Application No: EP/166/21/HH
Site Address: 8 Seawaves Close East Preston BN16 1LQ
Description of works: Single storey front extension and single storey rear extension.

Thank you for your internet representation made on 14th January 2022 which has been recorded as an objection with the comments as follows:

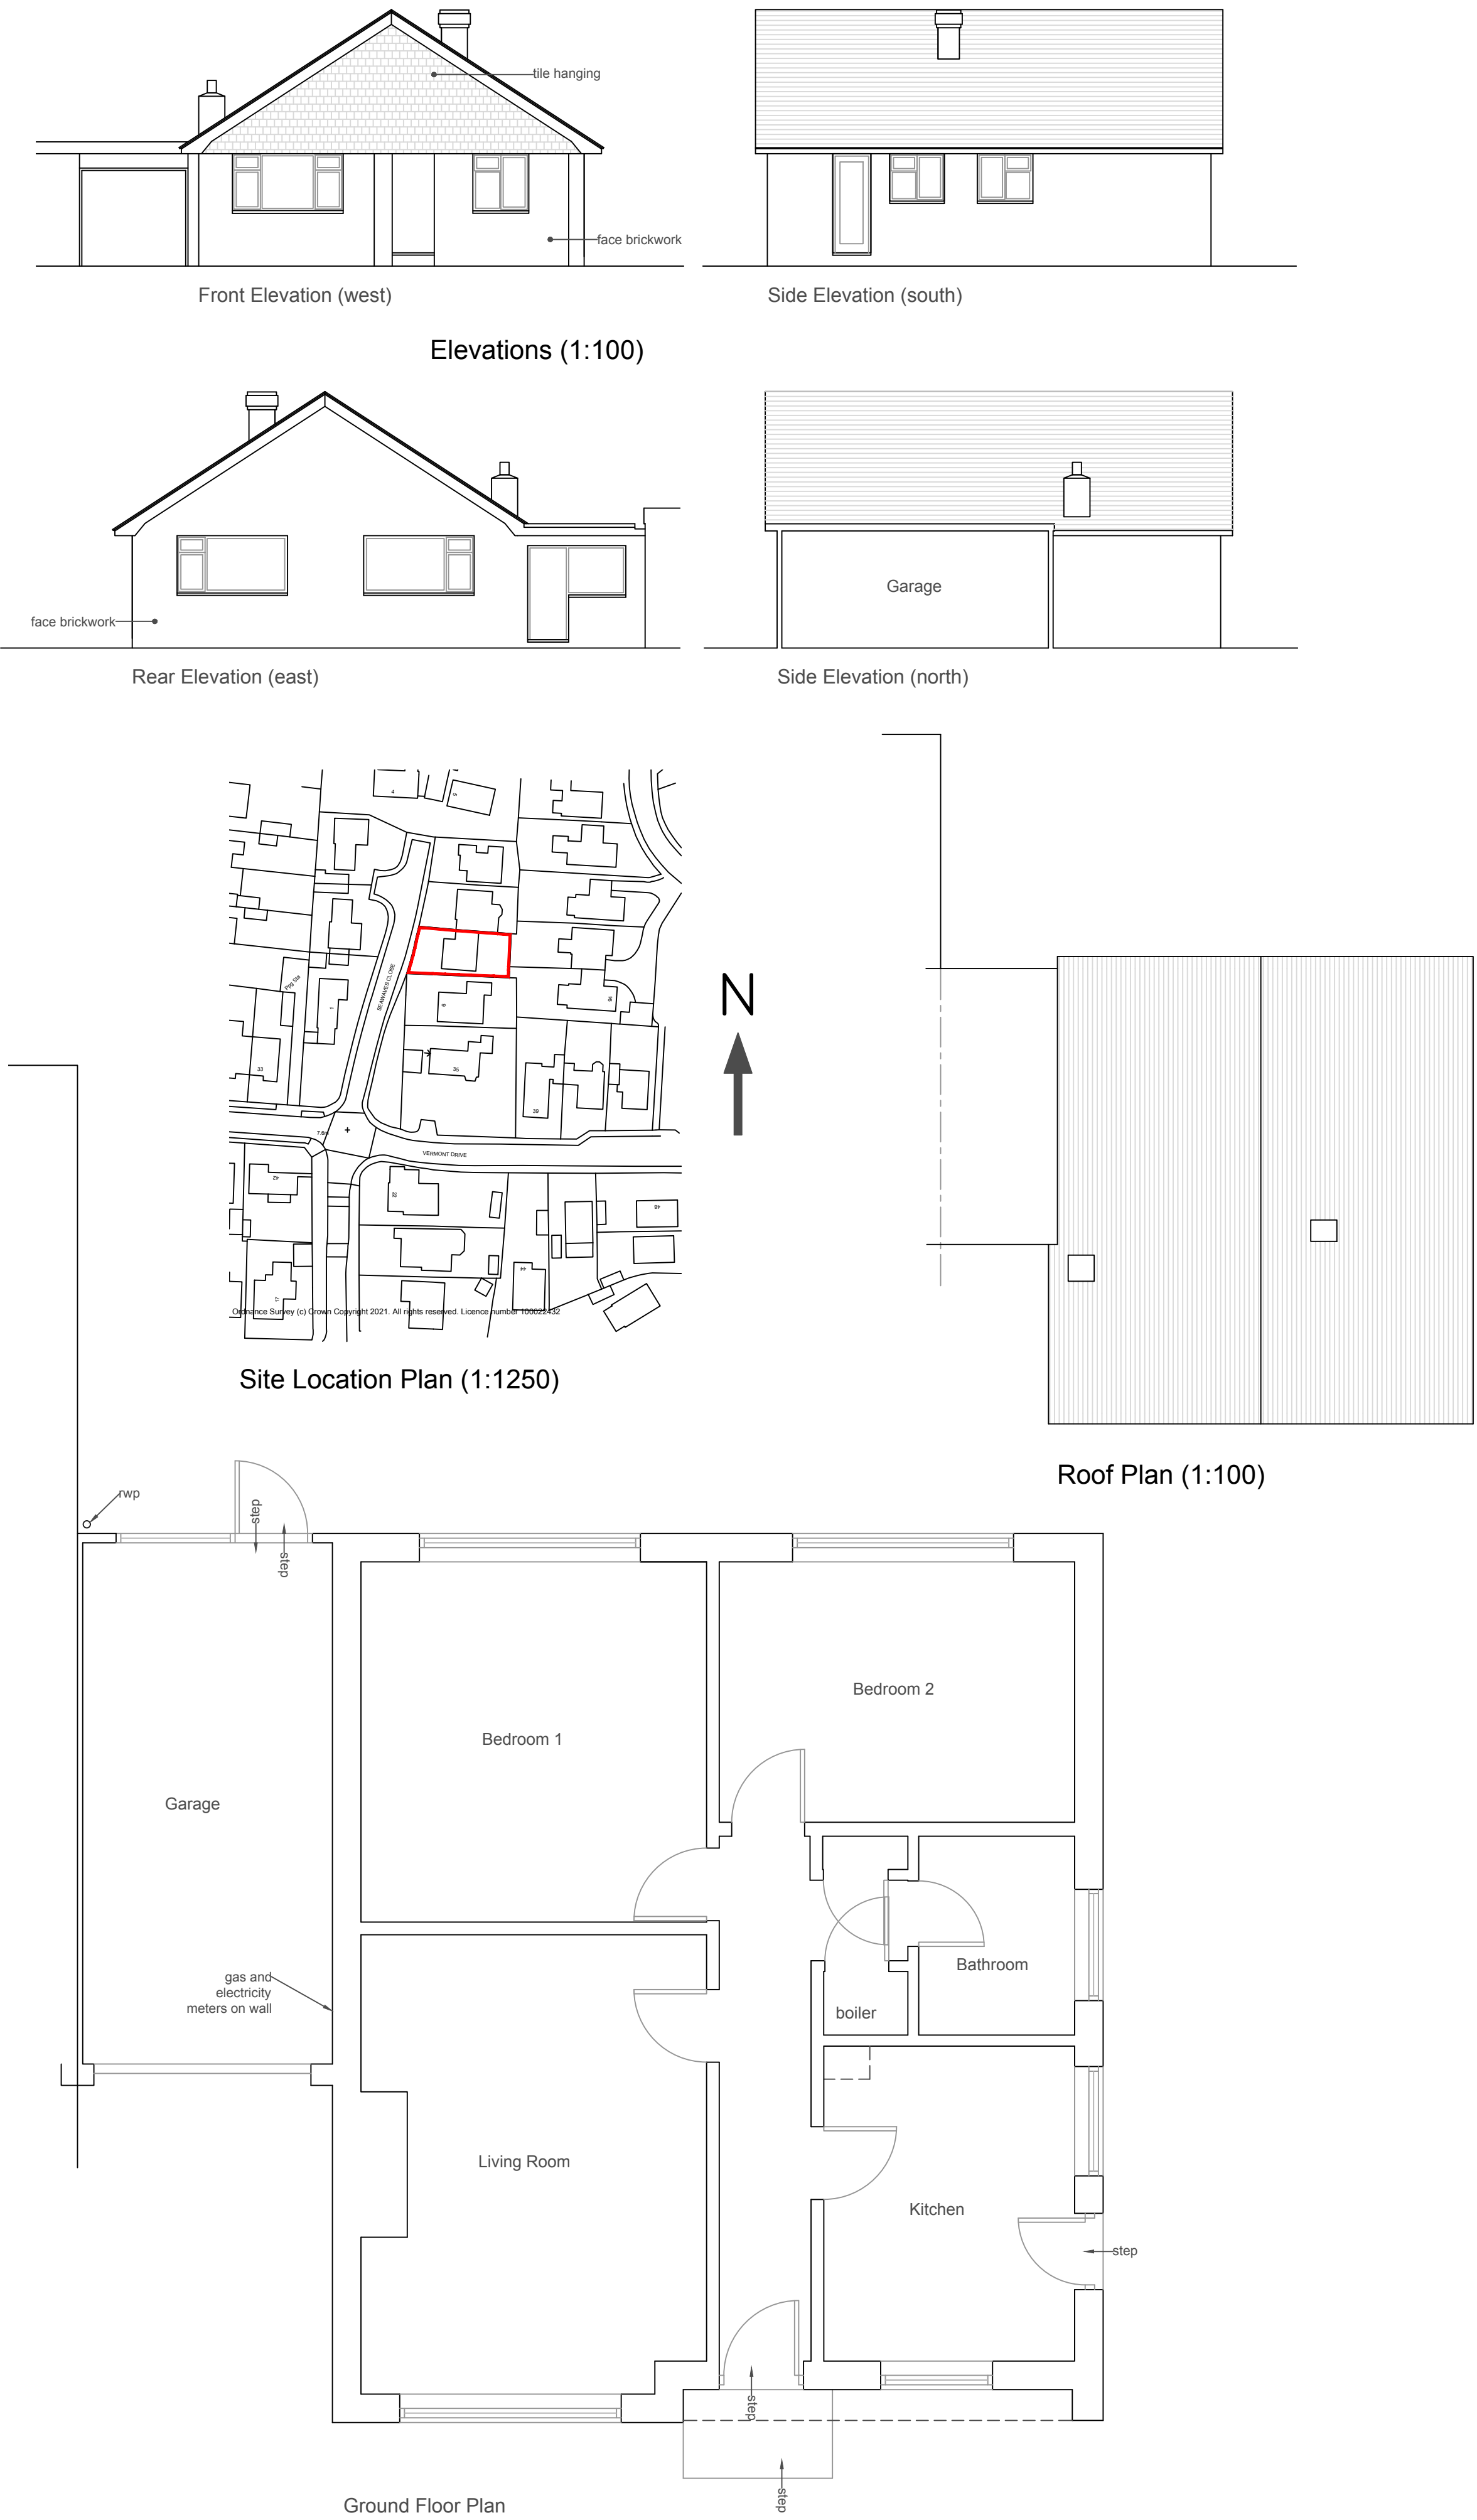
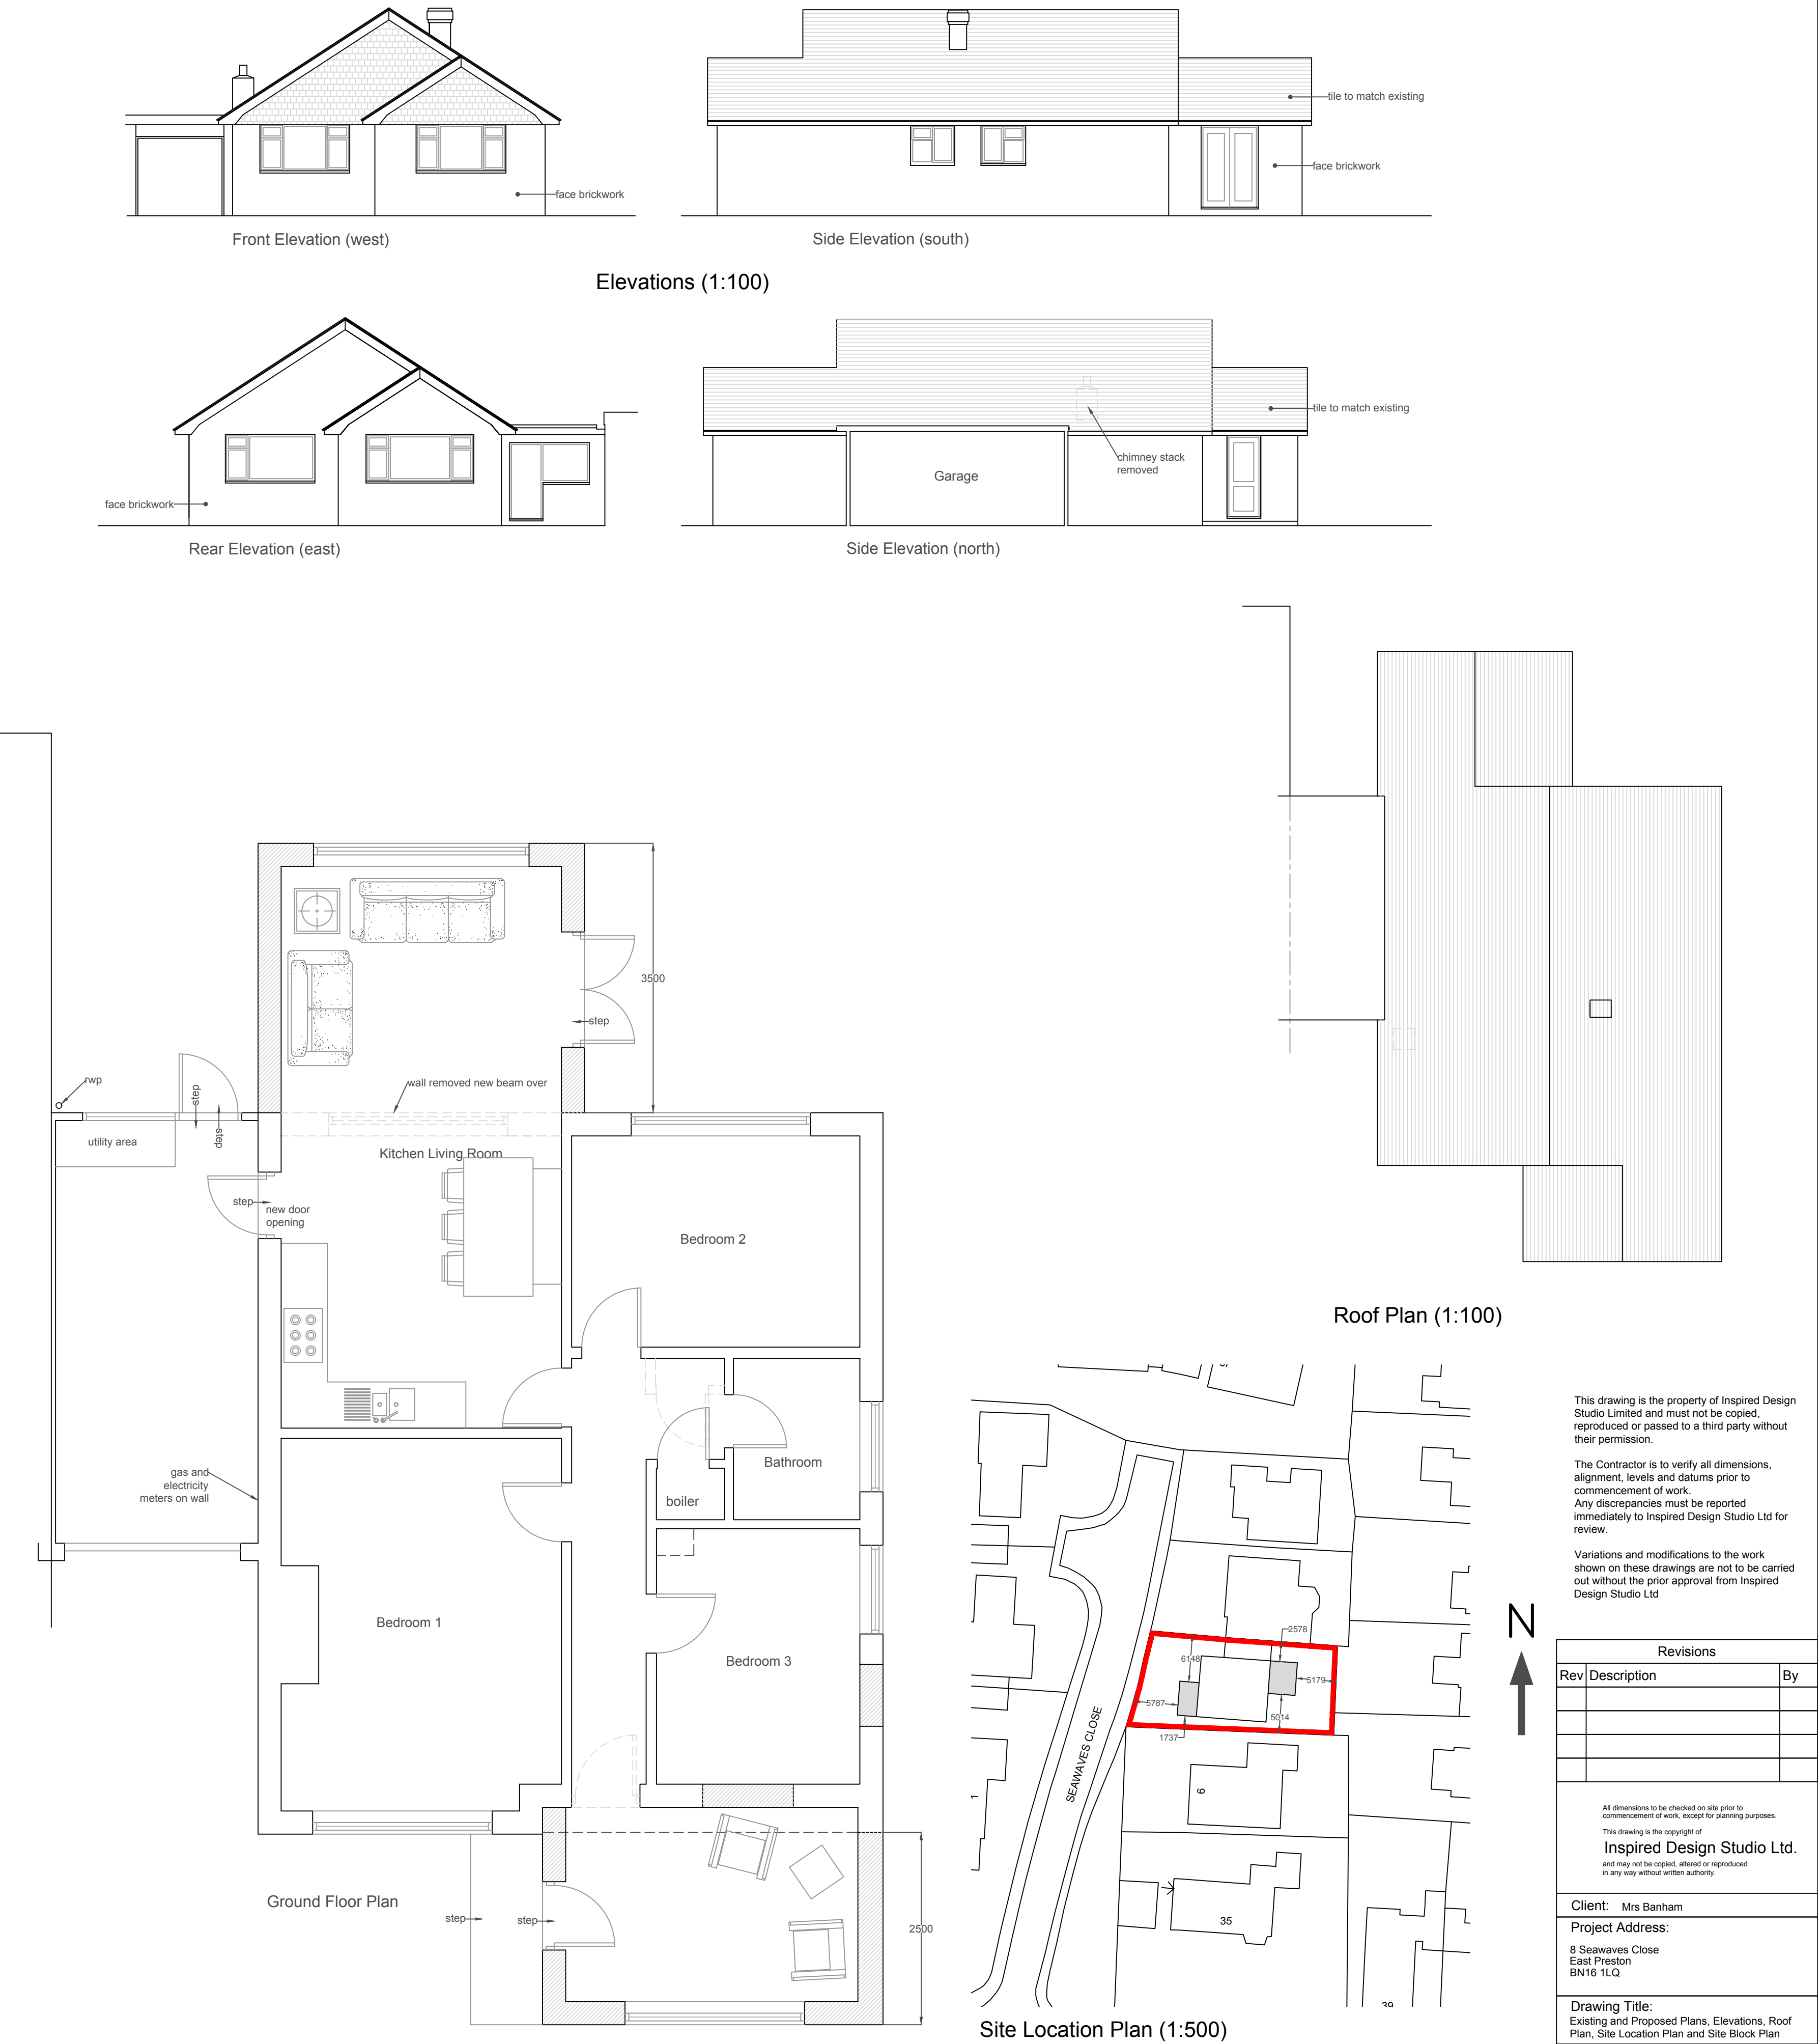
The committee was concerned the proposal for the development at the front of the building would alter the streetscene of a road which has remained pretty much as it was constructed. The committee was also concerned this proposal would be forward of the existing building line for the close. These reasons could make the proposal contrary to Arun Local Plan policies D DM1 and D DM4 and East Preston Neighbourhood Plan Policy 3.
